# CITY OF ALBUQUERQUE

May 4, 2022

**Re: Stripes Burrito Co.  
Address  
Traffic Circulation Layout  
Architect's Stamp 04-18-2022 (H11-D073)**

SEE SW SHEET FOR DUMPSTER INFORMATION
SEE FIRE-1 SHEET FOR INFORMATION

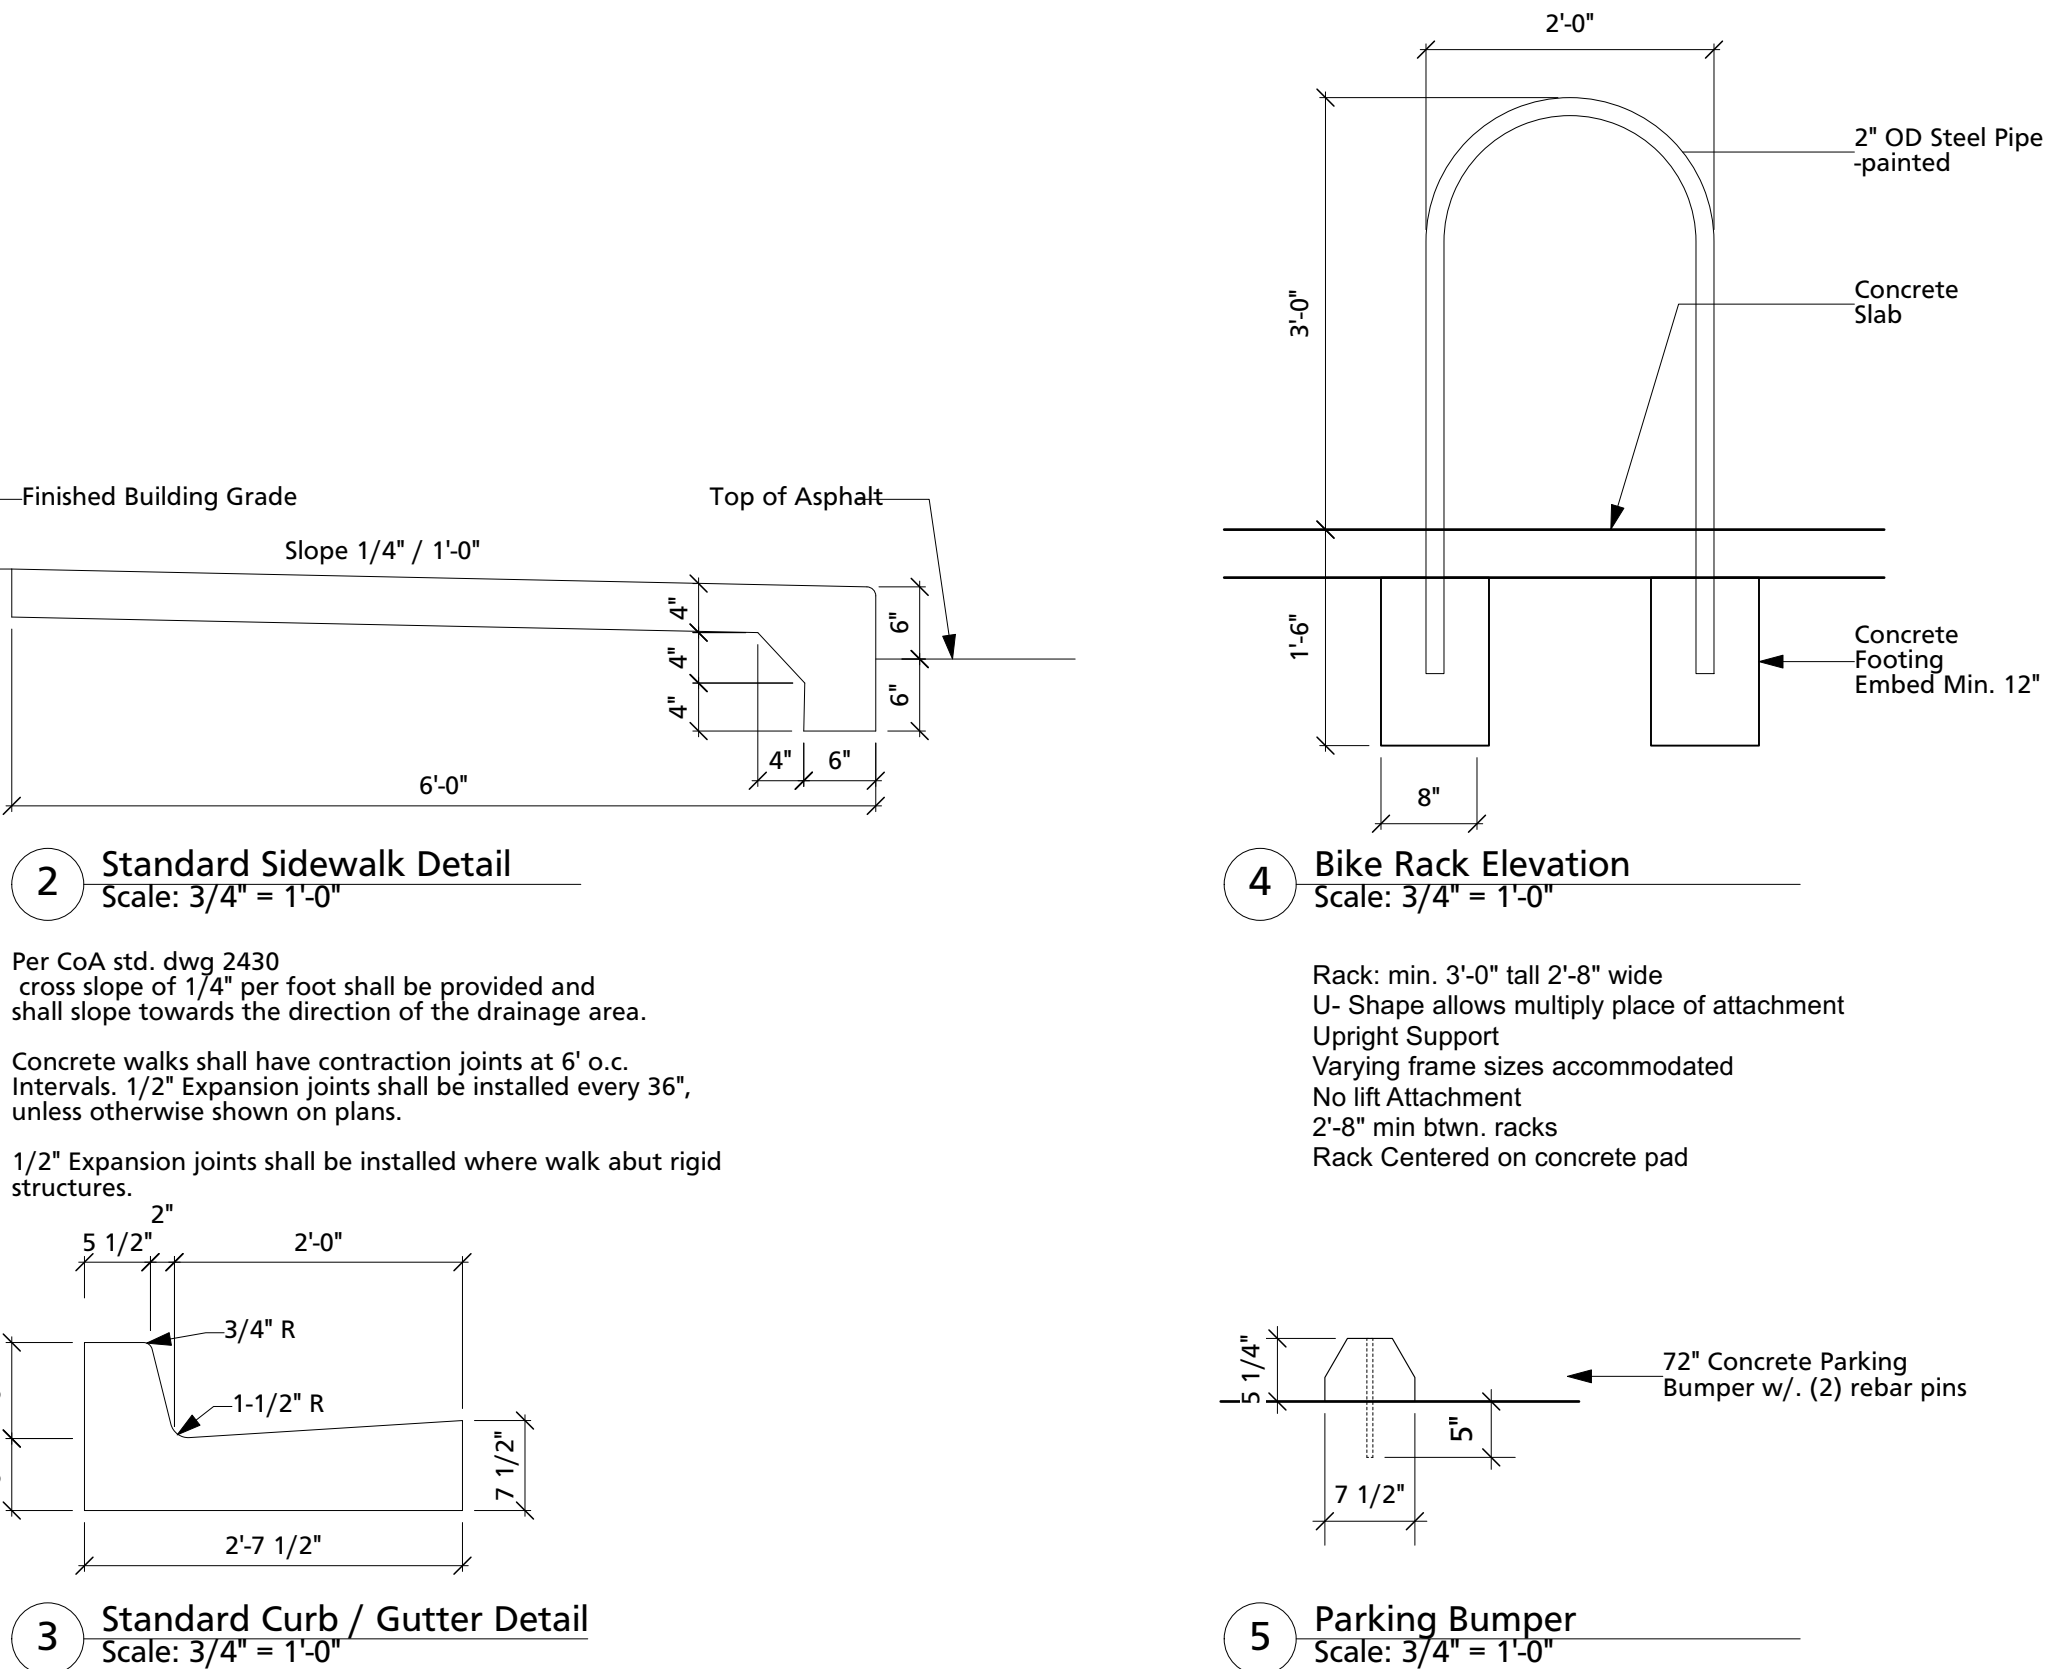
1. Listed are the number of parking spaces required by the IDO as well as the proposed number of parking spaces including bicycle and motorcycle parking.

**Coordinate/discuss with Zoning.**
2. Provide a street of the proposed Stripes Burritos Development.
3. **Queue length:**
  - Provide a queuing calculations to ensure it doesn't back into the entrance and 57<sup>th</sup> Street.

- What is the total vehicular queue length of the proposed drive thru shown on site plan? Will the queue land interfere with the parking? Explain?
4. The propose Freestanding Sign will need to be locate outside of COA ROW on private property (which includes **AIRSPACE**).

5. Please list the width and length for all proposed parking spaces and drive aisle. Some dimensions are not shown.
6. ADA curb ramps must be updated to current standards and have truncated domes installed at existing entrance off 57<sup>th</sup> Street NW. If not, then provide a new design to include truncated domes.

7. Internal ramps:
  - Will need details for the 6ft proposed pedestrian pathway from public sidewalk across drive aisle.
  - Shown is another ramp directly onto the drive thru lane Why? This is a safety concern for any patrons. Detail for this ramp will be needed was well.

- Do you need a ramp off ADA access aisle? Explain?
8. Show all drive aisle widths and radii. Some dimensions are not shown.
9. The minimum drive aisle dimensions are shown below

10. List radii for all curves shown. The minimum radius for internal is 15 ft. except the drive thru exit radius.
11. Per the DPM, a 6 ft. wide ADA accessible pedestrian pathway is required from the public sidewalk to the building entrances. Please clearly show this pathway and provide details. **Dimension proposed pathway.**

12. Per DPM, a 6 ft. wide ADA accessible pedestrian pathway is required from the ADA parking stall access aisles to the building entrances. Please clearly show this pathway and provide details.

13. All one-way drives shall have "One Way" and "Do Not Enter" signage and pavement markings. Please **show detail and location of posted signs and striping.**

14. Provide all pavement marking details of all proposed striping and pavement marking texts. This includes the striping around the parameter of the proposed drive thru lane.

15. The minimum drive through lane width is 12 feet with a 25 foot minimum radius (inside edge) for all turns. (A 15 foot radius can be used with an increase in lane width to 14 feet). Please dimension all lane widths and radii.

16. Keyed Note 2: Why are you proposing a 8 inch curb and gutter? when 6 inch curb and gutter is used for on site development.
17. Provide construction notes and details for proposed internal curbing around New building and landscaping.

18. Please provide a sight distance exhibit
19. Show the clear sight triangle and add the following note to the plan: "Landscaping and signage will not interfere with clear sight requirements. Therefore, signs, walls, trees, and shrubbery between 3 and 8 feet tall (as measured from the gutter pan) will not be acceptable in the clear sight triangle.

20. Shared Site access: driveways that straddle property lines, or are entirely on one property but are to be used by another property, shall have an access easement. Please include a copy of your shared access agreement with the adjacent property owner.

21. Add a note stating "All broken or cracked sidewalk must be replaced with sidewalk and curb & gutter." A build note must be provided referring to the appropriate City Standard drawing (2430 & 2415A).
